Subject: FW: 17-0347_Nihon University - Service Vehicle Access [SSD-9787]

I refer to the recent plans and associated documentation provided to Council in relation to the proposed Church Street service vehicle access for development proposal SSD – 9787 Nihon University.

Project	P1626 Nihon University Newcastle Campus			Scale 1:200 at A3
Date	23/10/2019	Prepared By	SL	
Drawing No.	SS01	Revision	A

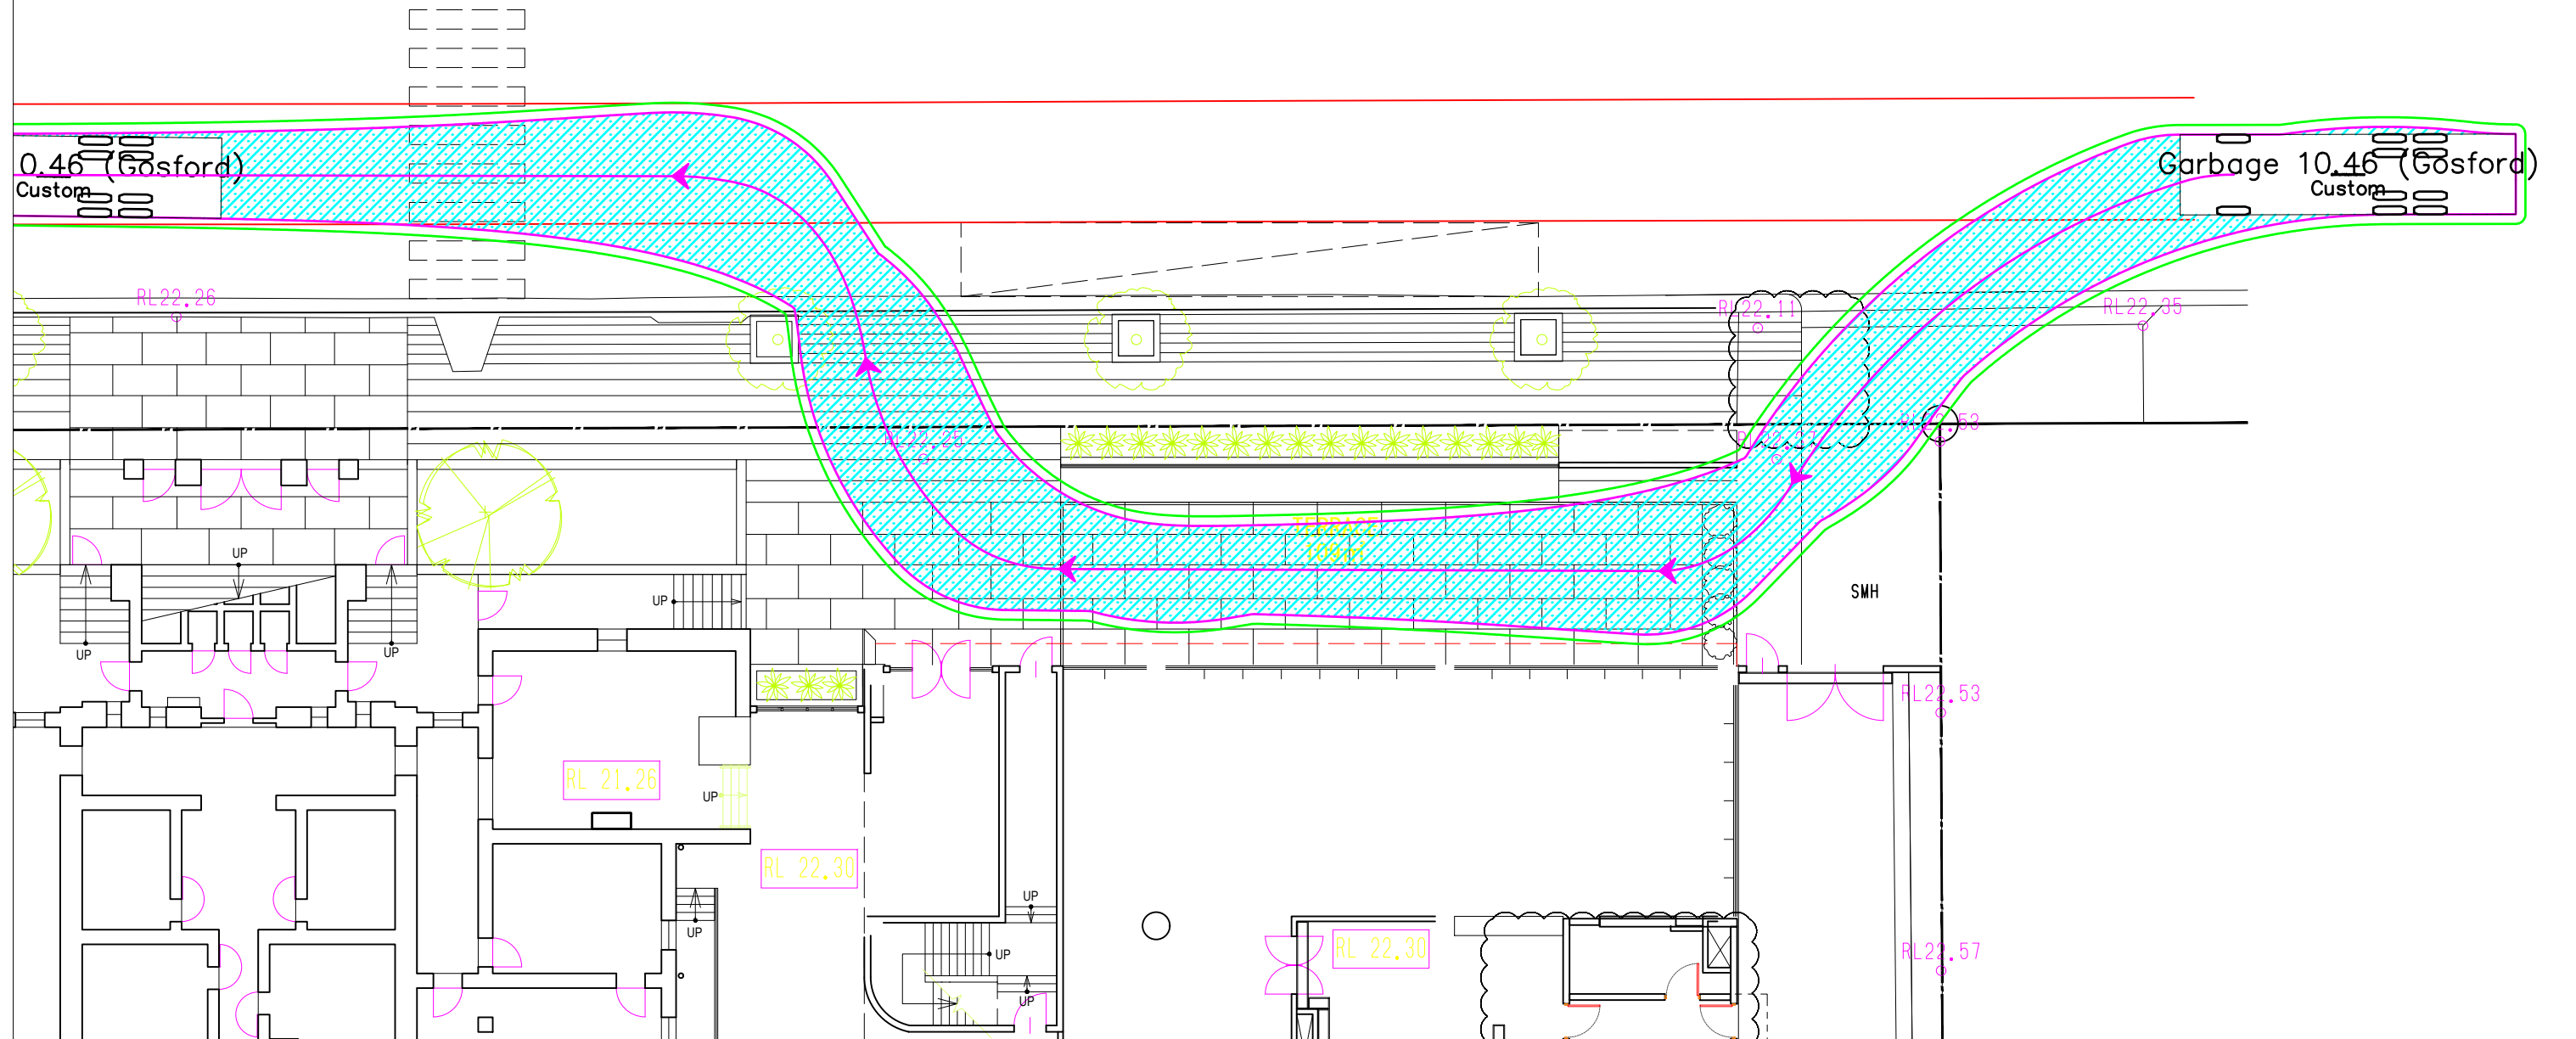
Council has reviewed the documentation and hereby provides 'in principal support' to the proposed service access as detailed on Architectural Plan by Azusa Sekkei Drg No. A-101 Rev 2 dated 30/10/2019, such operating generally as outlined in a revised memorandum dated 04 November 2019 with the operating hours of the proposed service vehicle access being confined to 7am – 8am and 7pm to 8pm Mon to Fri, 7am to 8am Sat and no service vehicle access on Sunday and public holidays.
